DOC17/365171
SSI 7400 MOD 4

**Notice of Exhibition - Sydney Metro City and Southwest (Chatswood to Sydenham)
Modification 4**

I refer to your letter received 27 June 2017 by the Office of Environment and Heritage (OEH) regarding the above modification to the Sydney Metro City and Southwest (Chatswood to Sydenham) (SSI 7400 MOD 4). OEH understands that the proposed modification will expand the proposal to include additional works around Sydenham and Marrickville Stations.

Figure 10: Proposed flood levels change (one per cent AEP plus ten per cent for climate change) (Source: RtS)

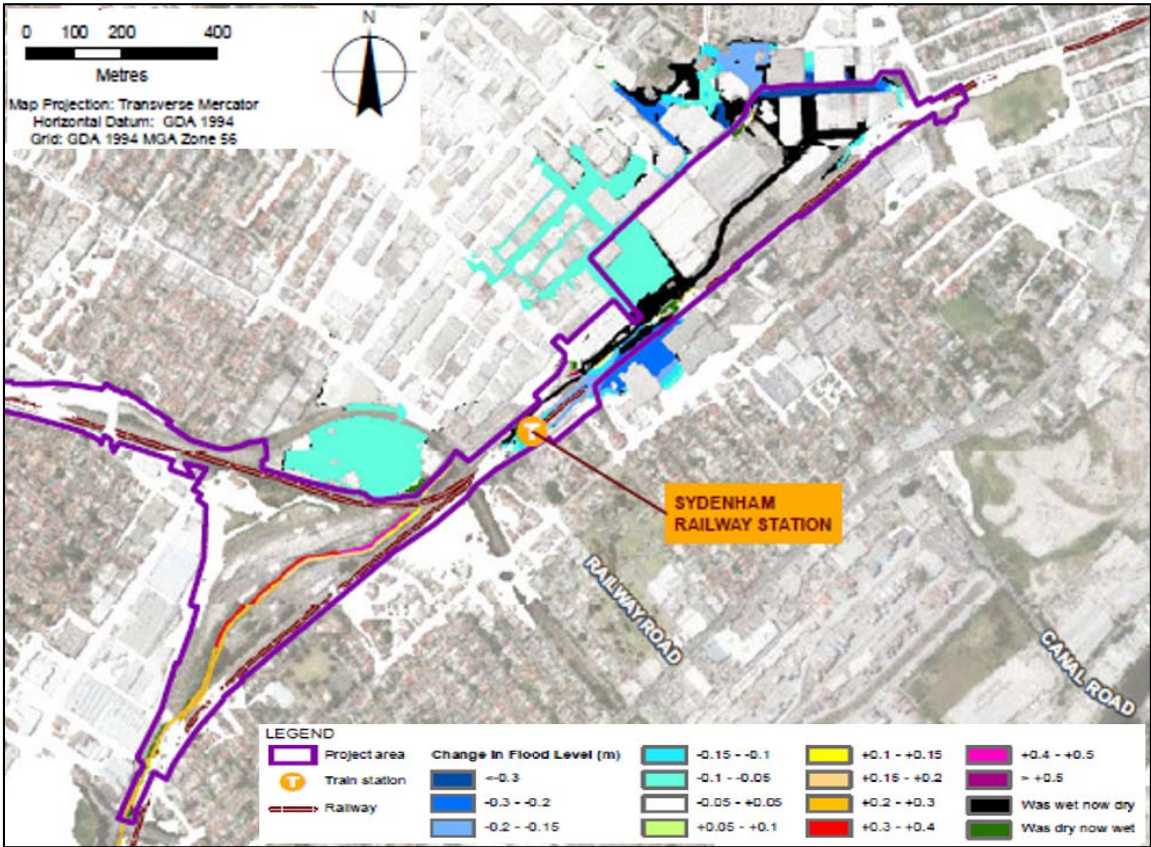
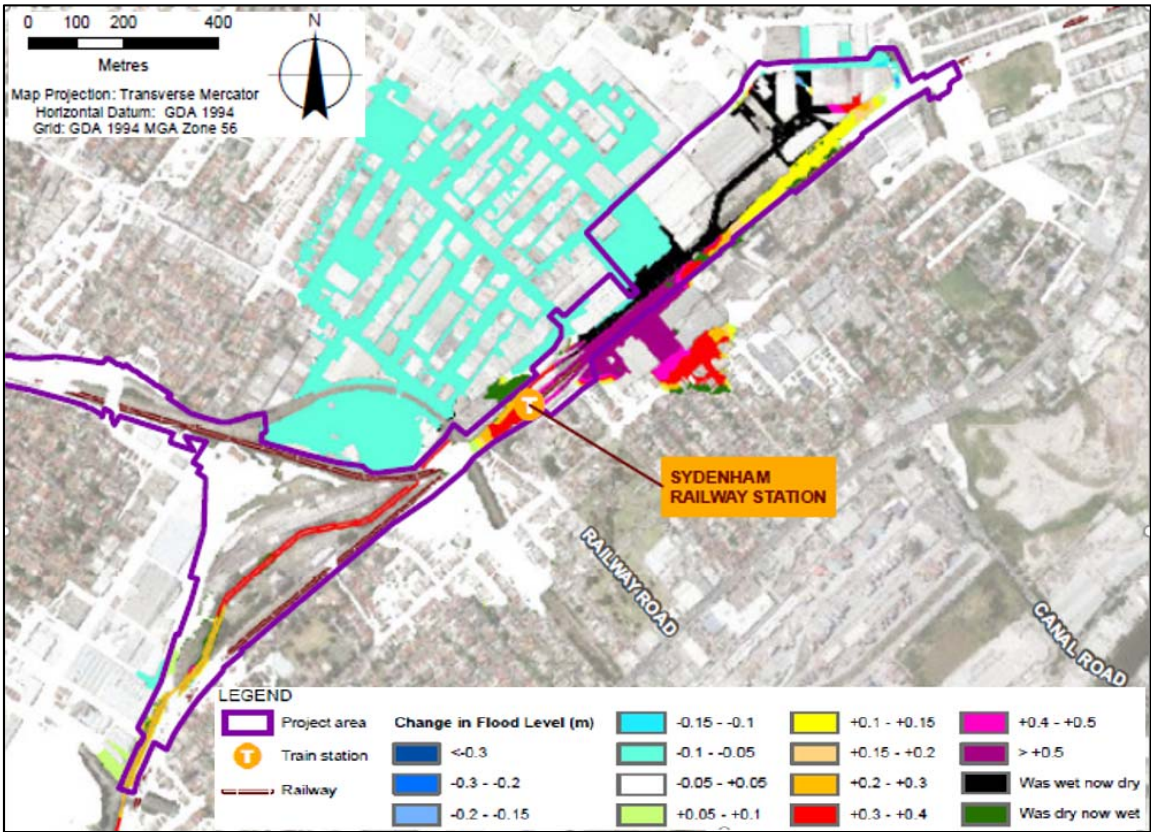
OEH has reviewed the documentation provided and considers that the existing conditions of consent in relation to Aboriginal cultural heritage are sufficient to manage the works proposed by the modification. However, Chapter 17 of the Sydenham Station and Sydney Metro Trains Facility South Modification Report prepared by Transport for NSW (undated) indicates that the modification will result in increases in flood depth and extent in the vicinity of Fredrick and Sutherland Streets. From a floodplain risk management perspective, it is prudent that the proponent adequately investigates the following:

- Identify additional properties that would be affected by over floor flooding in 1% AEP, which in existing condition are subject to ground flooding only.
- Identify additional properties that would be within the flood planning area, which are currently above the flood planning level.
- Identify additional properties that would become flood affected due to the increase in the PMF extent.
- Identify the potential for increase in flood damage due to the above points.
- Address impacts on emergency management planning.
- Undertake a consultation process with affected property owners and Inner West Council.
